DRB CASE ACTION LOG (PREL & FINAL)

DRB Application No.: 04DRB-01909 (P&F)
Project Name: Journal Center Phase 2, Unit 2
Agent: Precision Surveys Inc.

APPLICATION NO. 06AA-00009	PROJECT NO. 1003782
PROJECT NAME JOURNAL CENTER 2	LOTS 12, 13, 14
EPC APPLICATION NO.	
APPLICANT / AGENT MARK	PHONE NO. 792-8160
ZONE ATLAS PAGE D-17	
(SDP for SUB), (SDP for BP), (FINAL PLATS), (MASTER DEV PLAN), (IR), (AA)	
ONE STOP COMMENT FORM LOG

DRB Application No.: **04DRB-01773 (SBP)**
Project Name **Masthead Point @ Journal Ctr.**
Agent: **Dorman Breen Architects**

SHEET: C-1.1

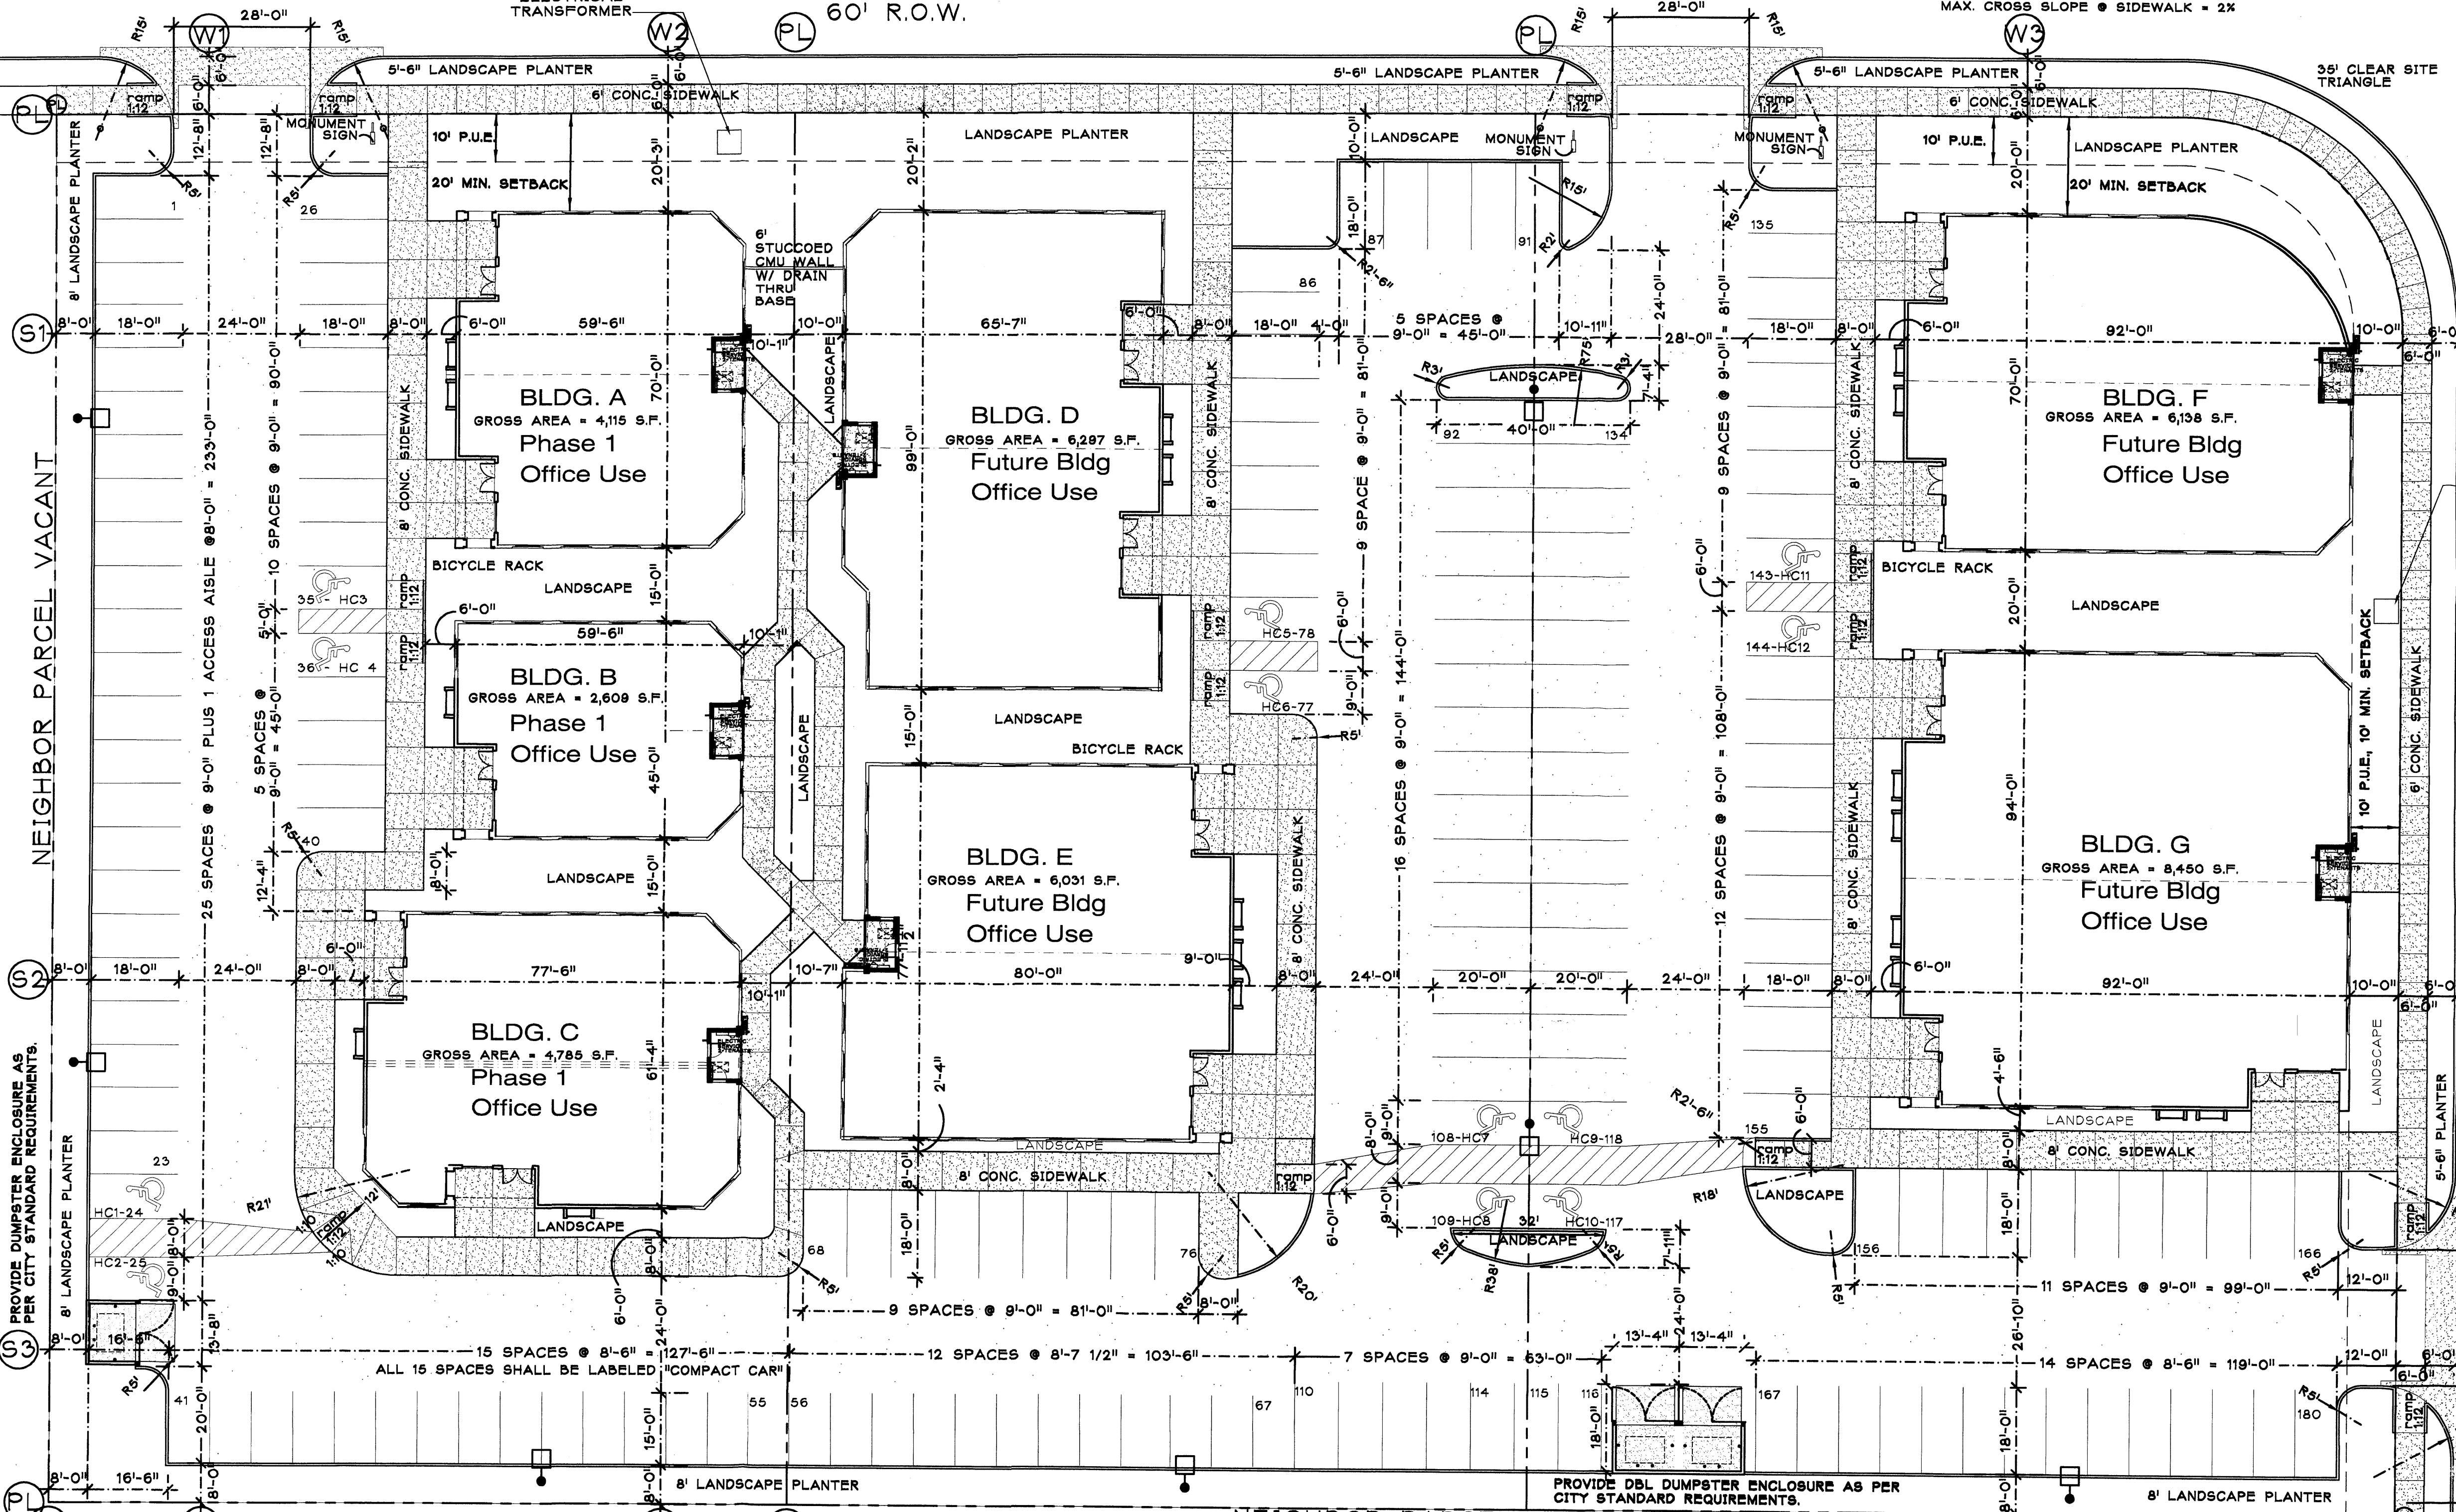
TRANSPORTATION DEV (505) 924-3990		
PLANS DISAPPROVED	DATE	DATE
PLANS APPROVED NSF	DATE 1/4/06	DATE
COMMENTS:		
No object on the condition that the 4th monument sign is located outside of COA ROW (includes foundation/footing)

- TRANSPORTATION: (1) X - ACCESS ACROSS HIGHWAYS
- (2) COMPACT SPACE LAYOUTING
- (3) OFFSITE MITIGATION
- (4) ADA RAMP @ DRIVEWAY & MASTERY

NORTH ELEVATION

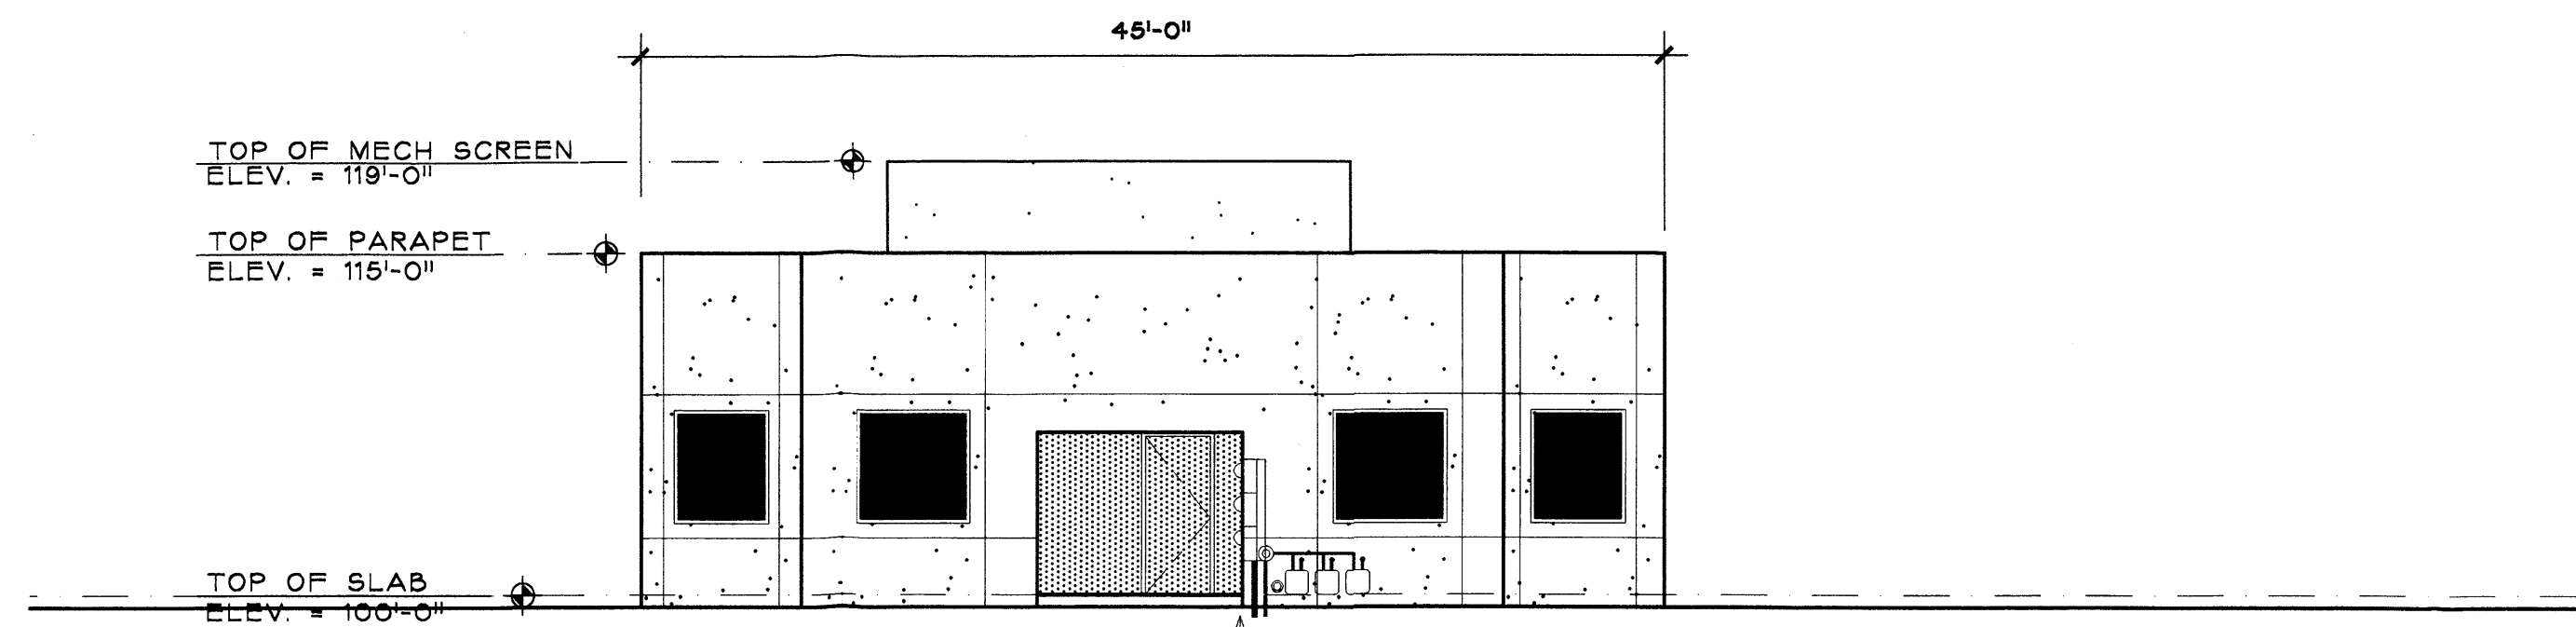
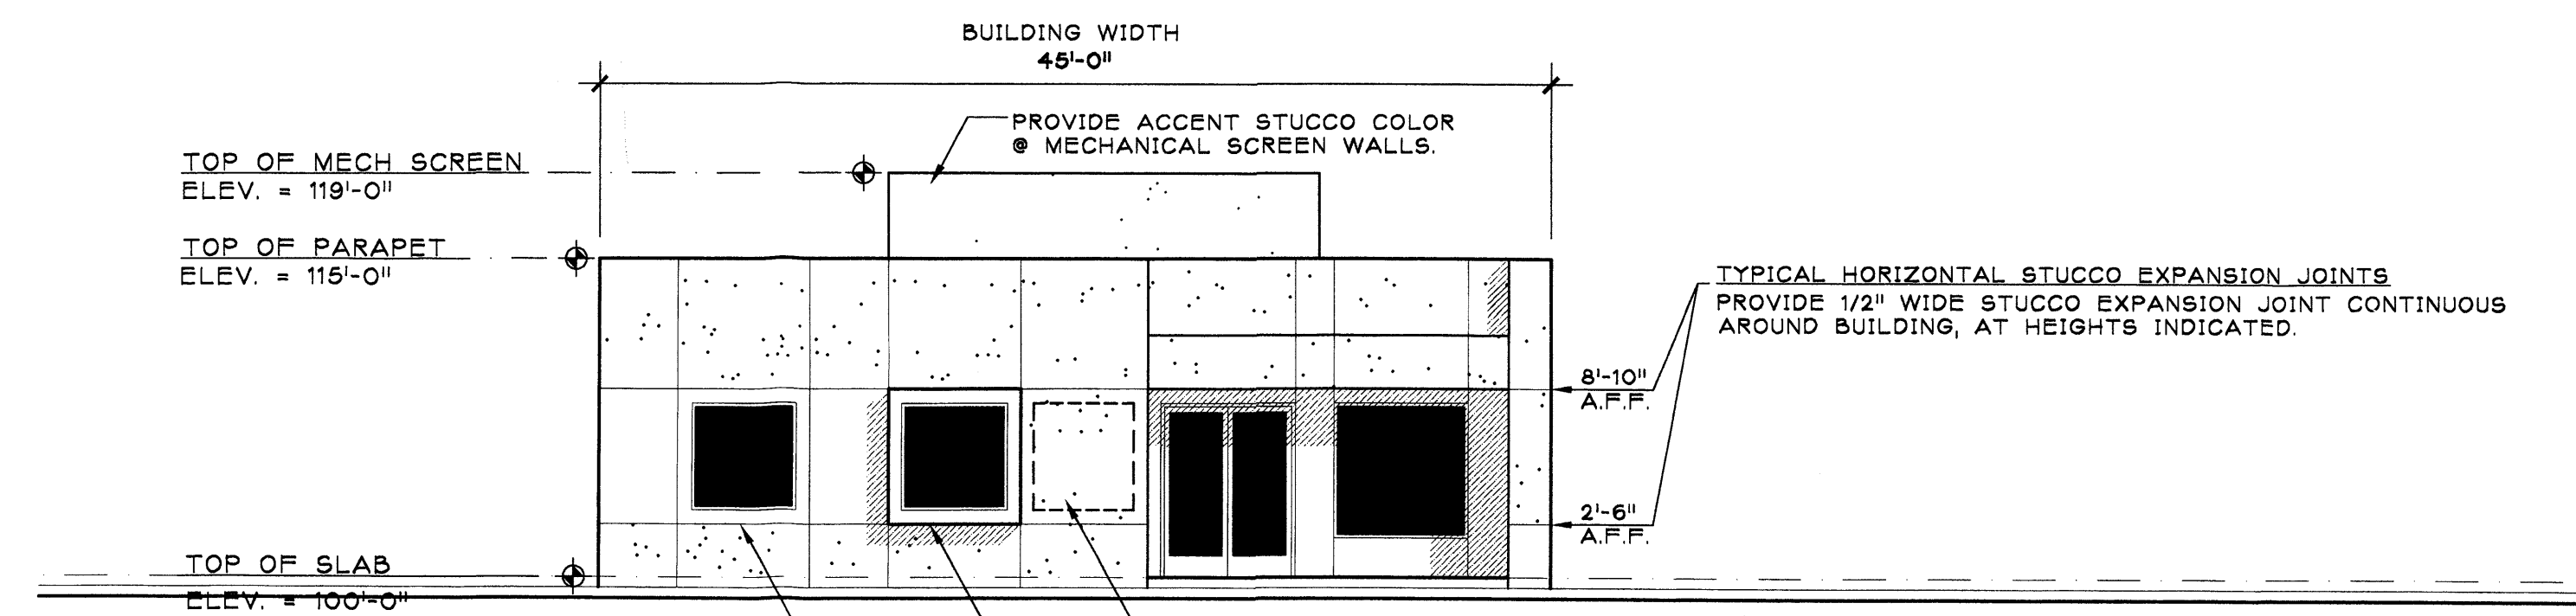
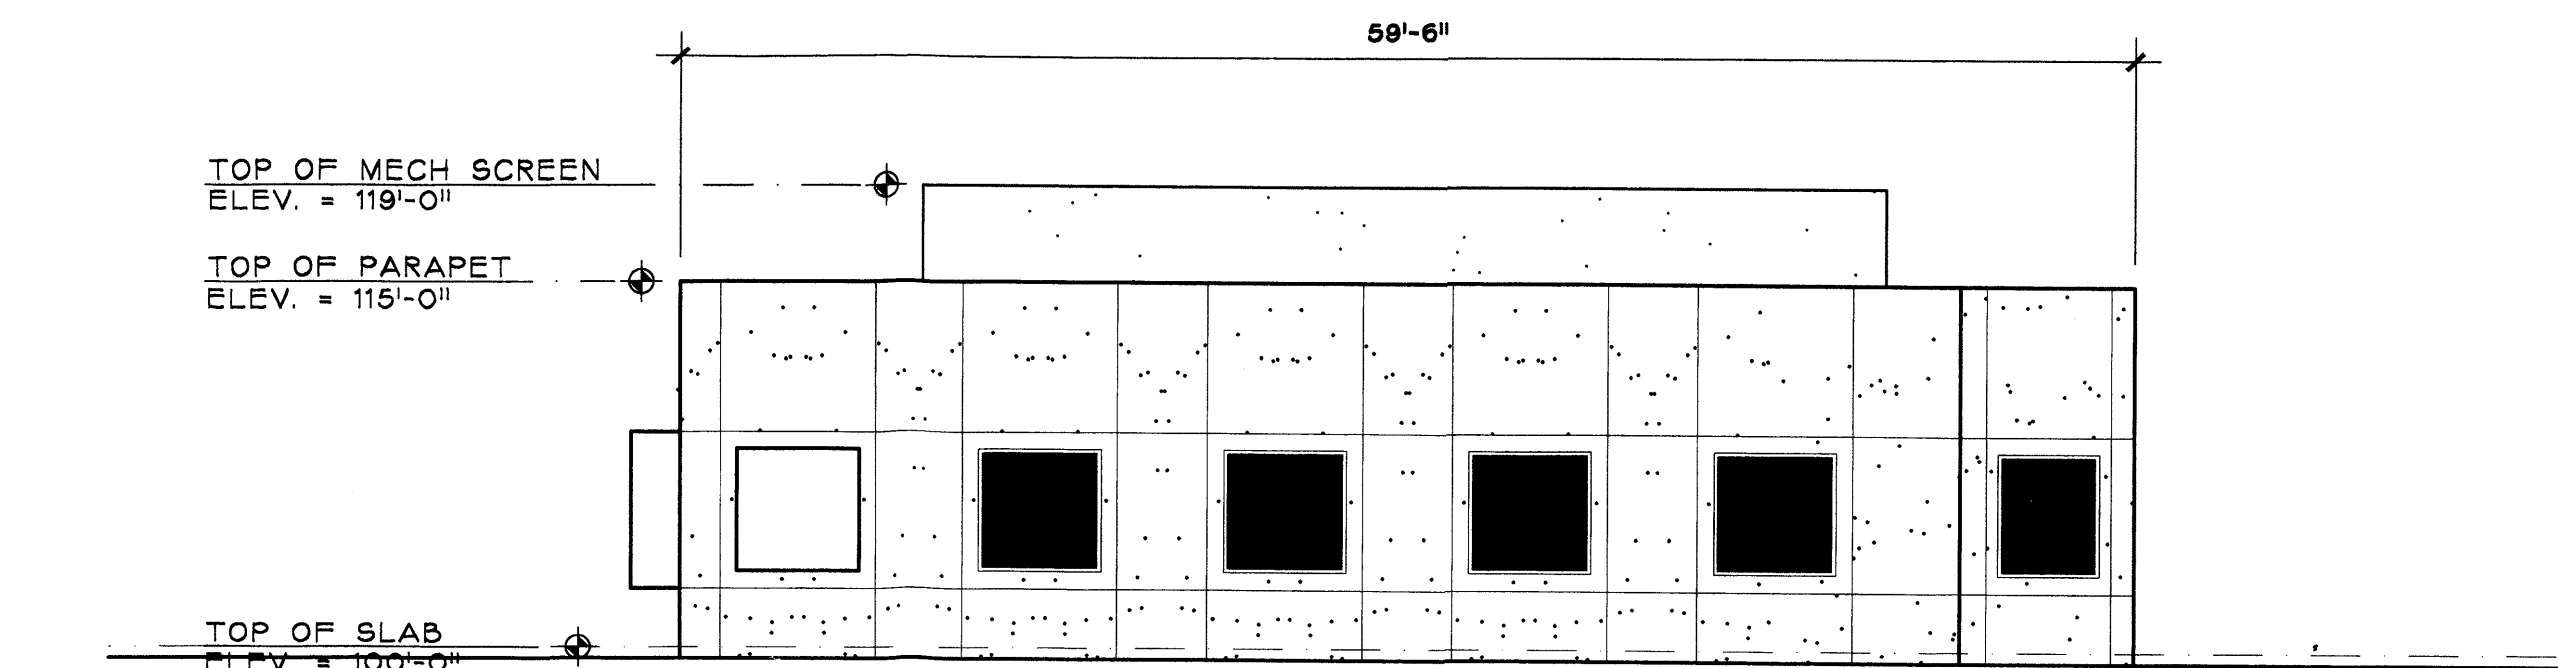
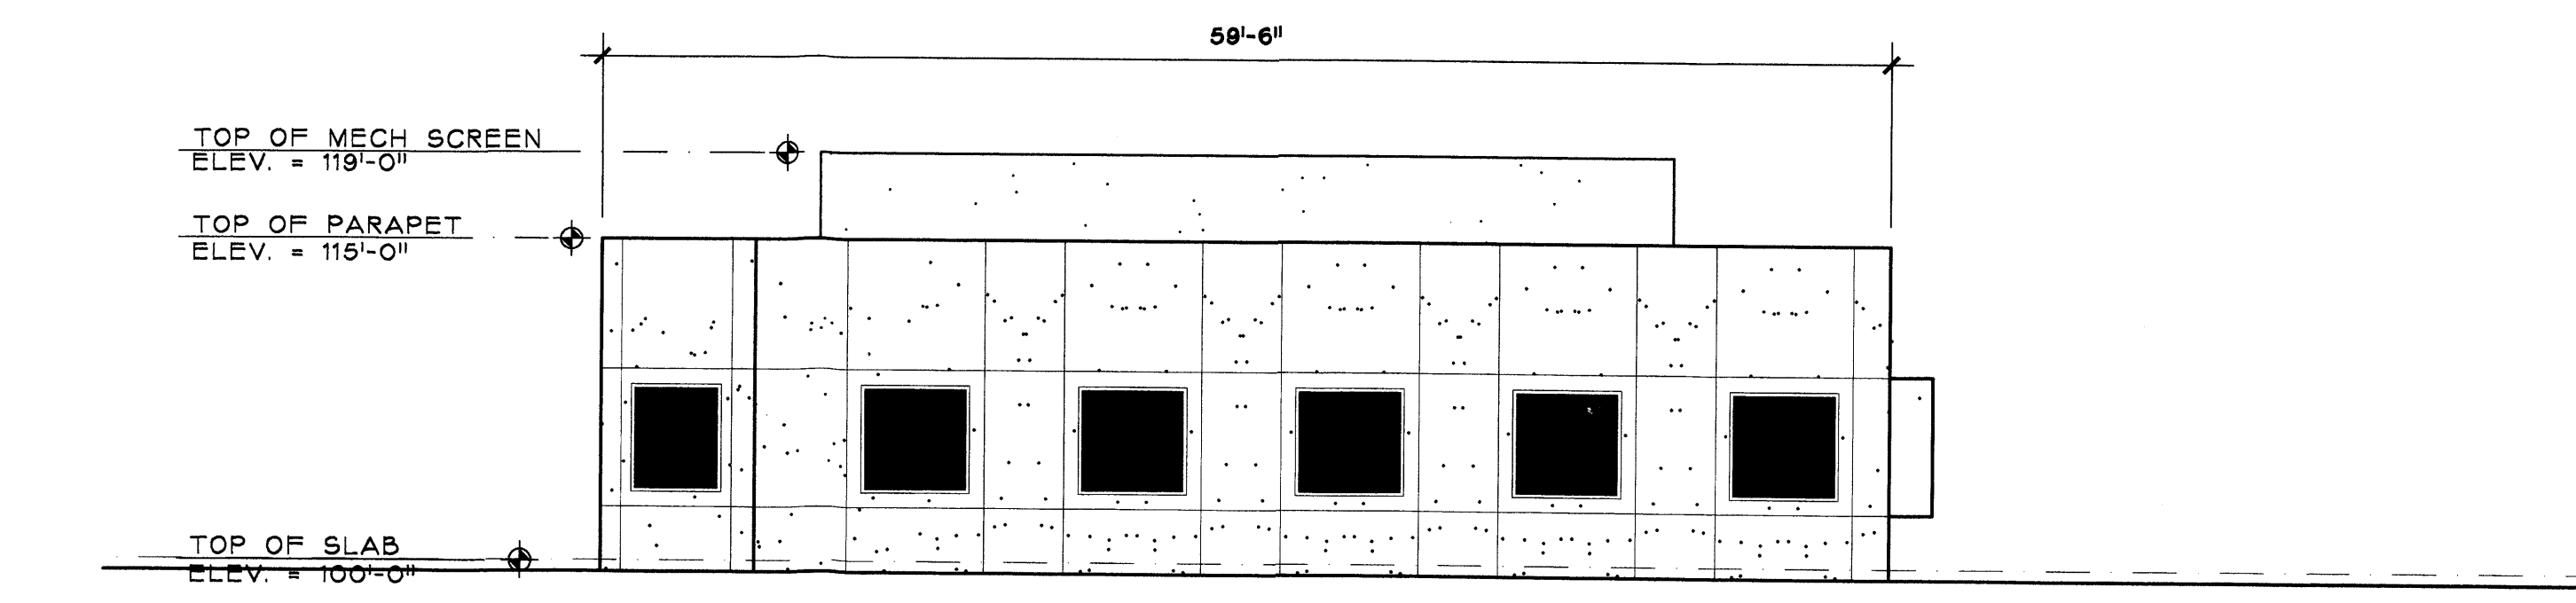
- PLANNING (Last to sign): Scuffed vicinity map on SP sheet
- elevation drawings are false containing
- Printed plat approved at DRB
